CITY OF ALBUQUERQUE

August 26, 2020

**Re: Lot 2 Block 3 Unit 18 Volcano Cliffs, S.A.D. 228
6612 Cuervo Pl NW
Request for Permanent C.O. – Not Accepted
Engineer's Stamp Dated: 10-29-19 (D0D003S2)
Certification dated: 6/12/2020**

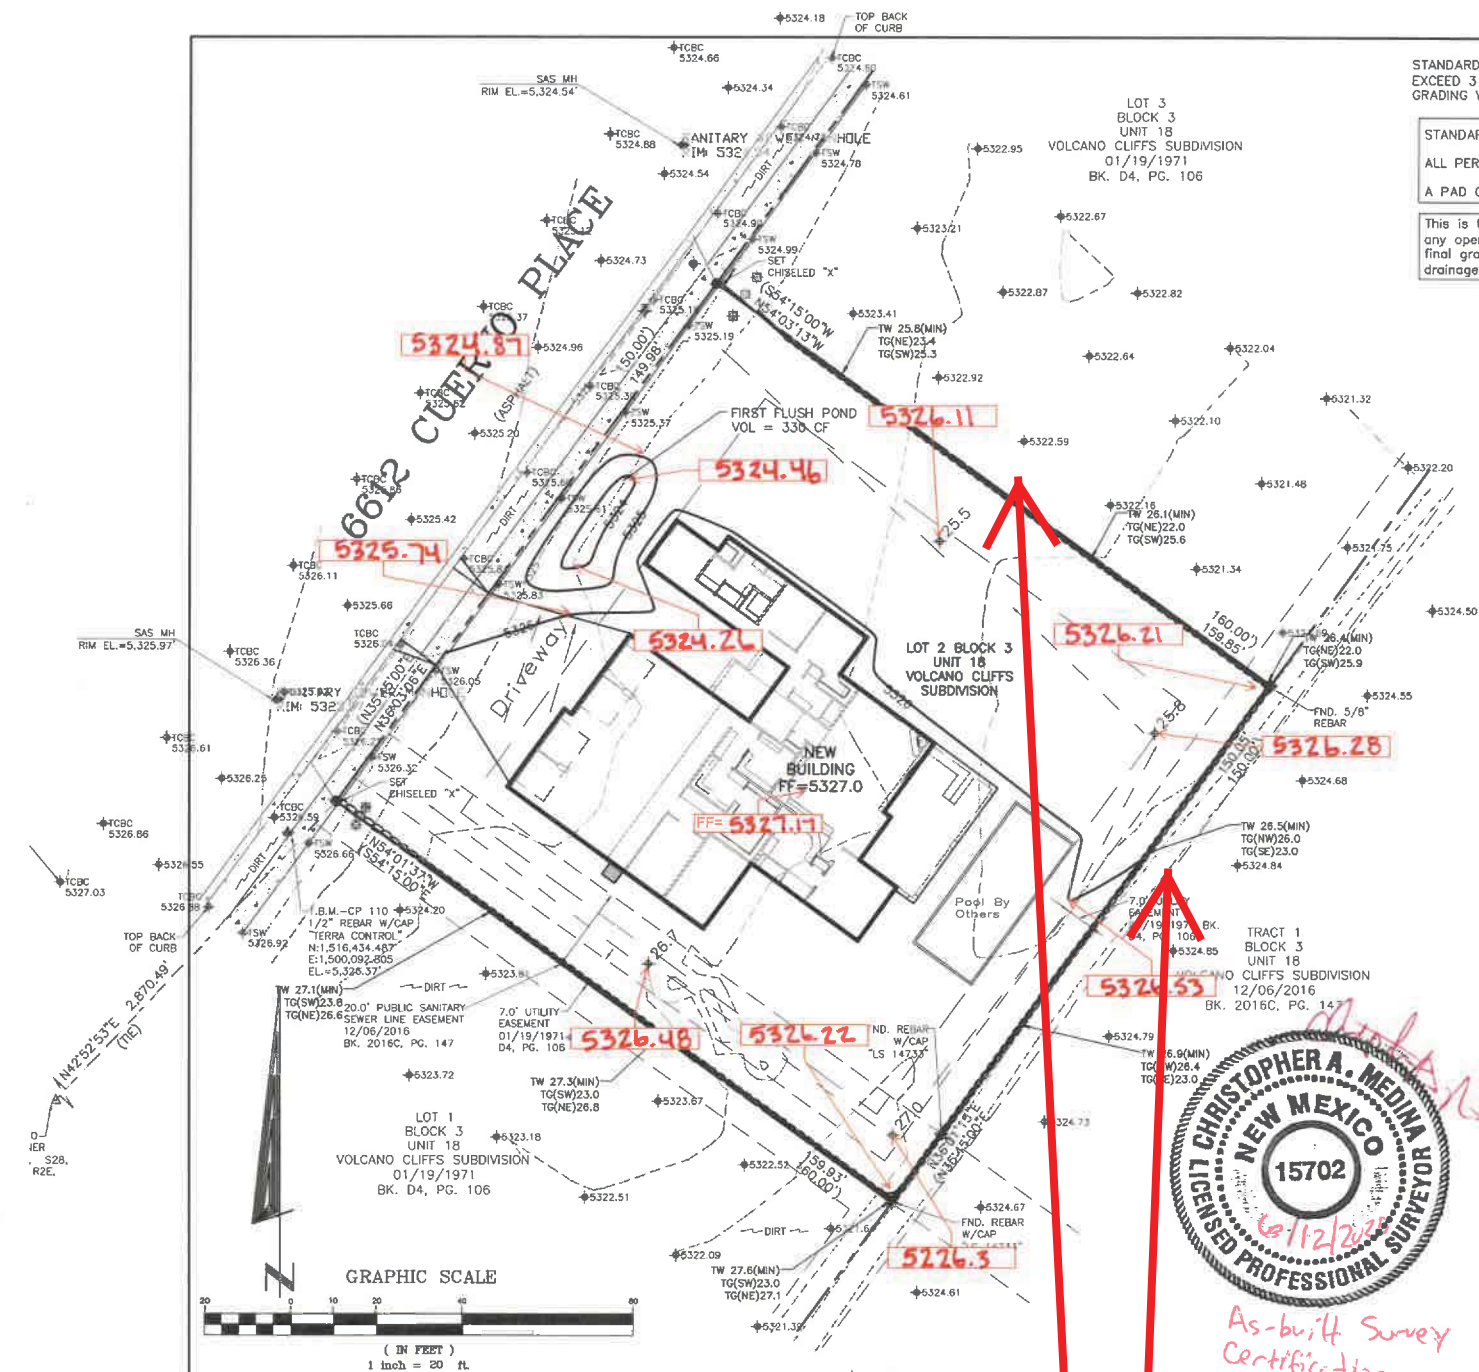
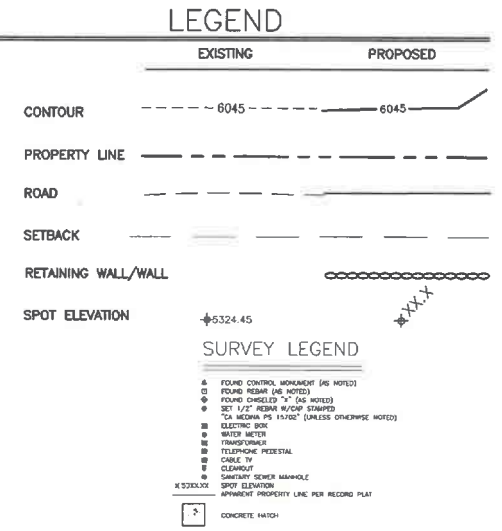
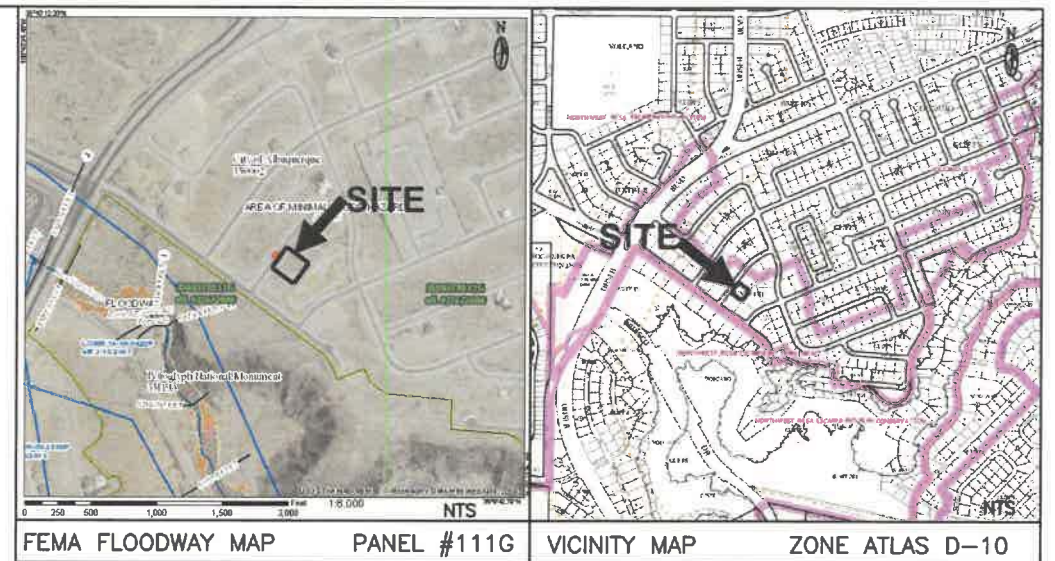
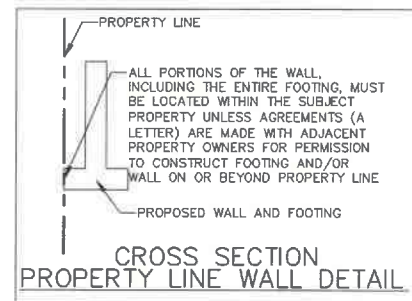
- Provide how erosion will be prevented on the east side of property, outside the block wall.
